December 19, 2024

**Re: Mountain Road Rehab Facility
Traffic/Safety Study (J15D053)**
Engineer's Stamp 7-29-24
Via email tbrown@tierrawestllc.com

The subject Traffic/Safety Study (Study) DRAFT received on December 5, 2024, has been reviewed by the City of Albuquerque Planning Development Transportation Section and provides the following comments:

<b>NOBIS REHAB HOSPITAL</b> 1100 WOODWARD PL.	DRAWN BY pm
	<b>SITE PLAN</b>	DATE 10-3-24
	5571 MIDWAY PARK PL NE ALBUQUERQUE, NEW MEXICO 87109 (505) 858-3100 www.tierrawestllc.com	DRAWING 2023123-SP
RONALD R. BOHANNAN P.E. #7868	SHEET # <b>SP-1</b>	JOB # 2023123

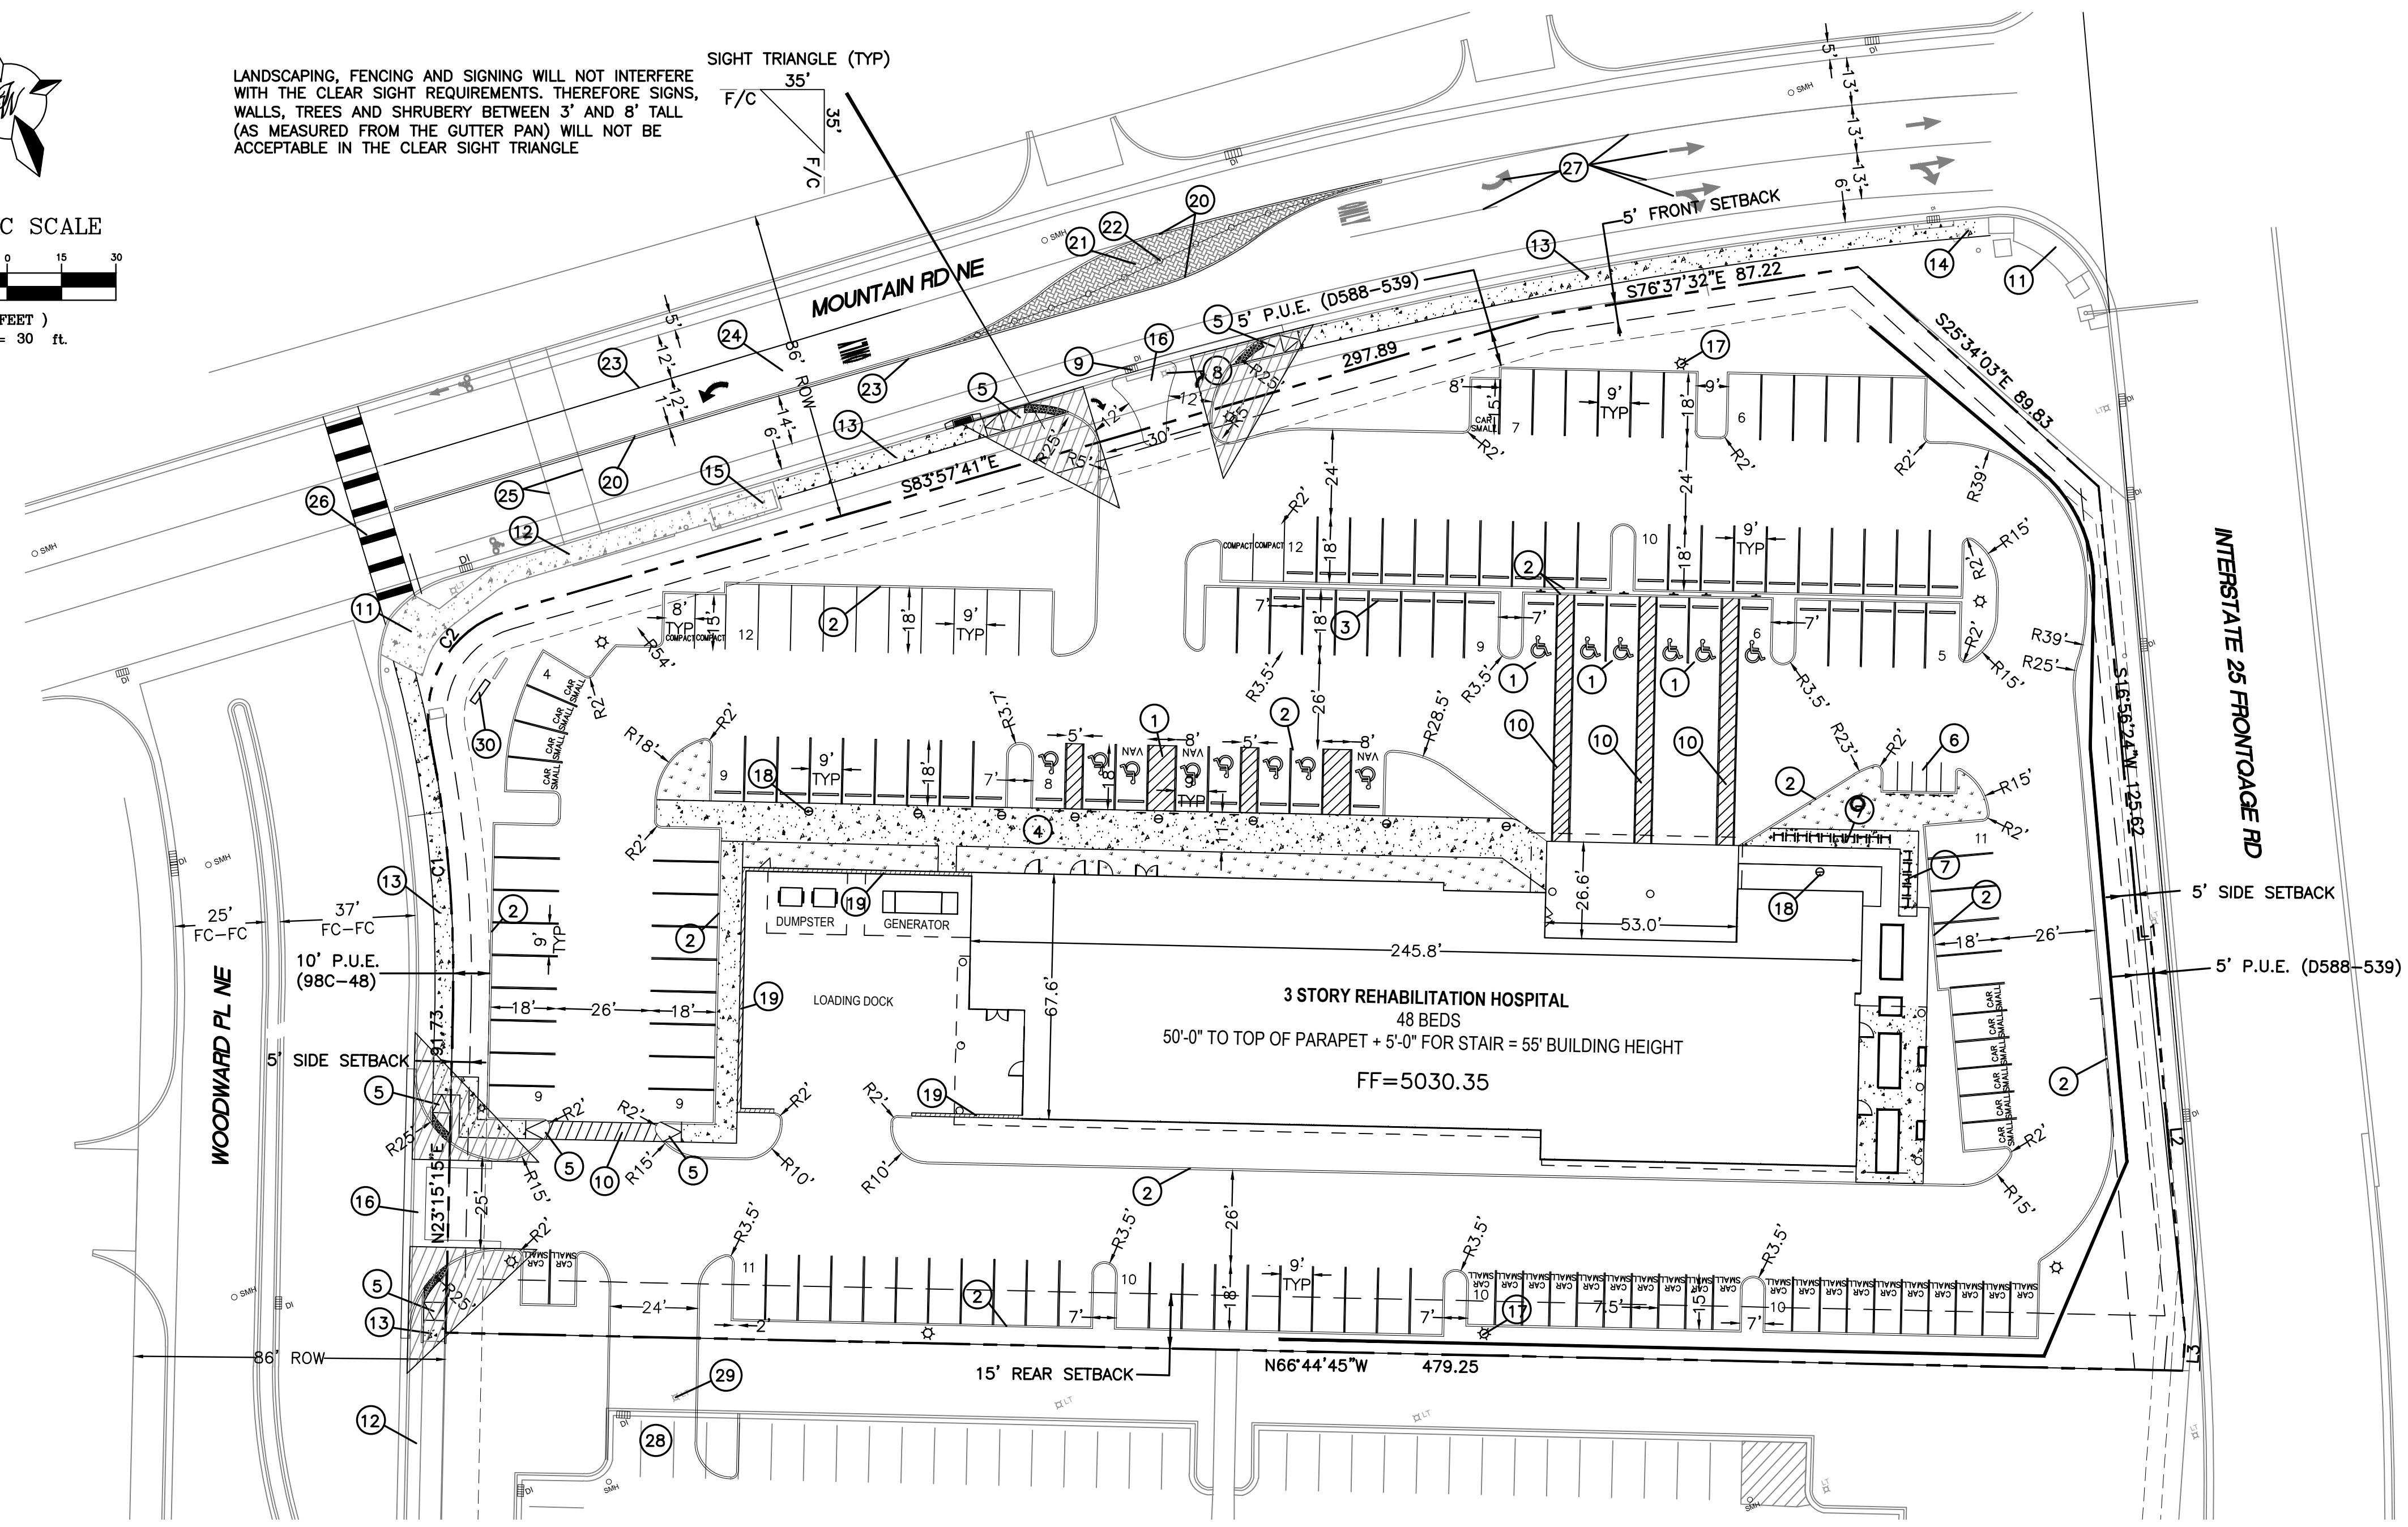
2. The "Ltd" and "No Access" cases will not be considered. It is requested they be removed from the Study, for brevity.
3. Some improvements shown on the Site Plan will remove the SBL from the APS center driveway. Provide approval from APS, if you wish Transportation Section to consider removing the SBL from this driveway. If you do not have approval from APS, then remove the improvements shown on the Site Plan in Mountain Rd in this area.

5. The improvements shown in Mountain Rd ROW on the Site Plan at Driveway "B", may not prevent NBL turning movements for some drivers.
6. Provide details of neighborhood concerns expressed at public meetings.

7. Show Embassy Driveway and access easement on the Site Plan.
8. There are few/no crashes presented in the Study on Mountain Rd fronting this project in the past 5 years. Should all the mitigation occur at Mountain Rd and the I-25 frontage road?
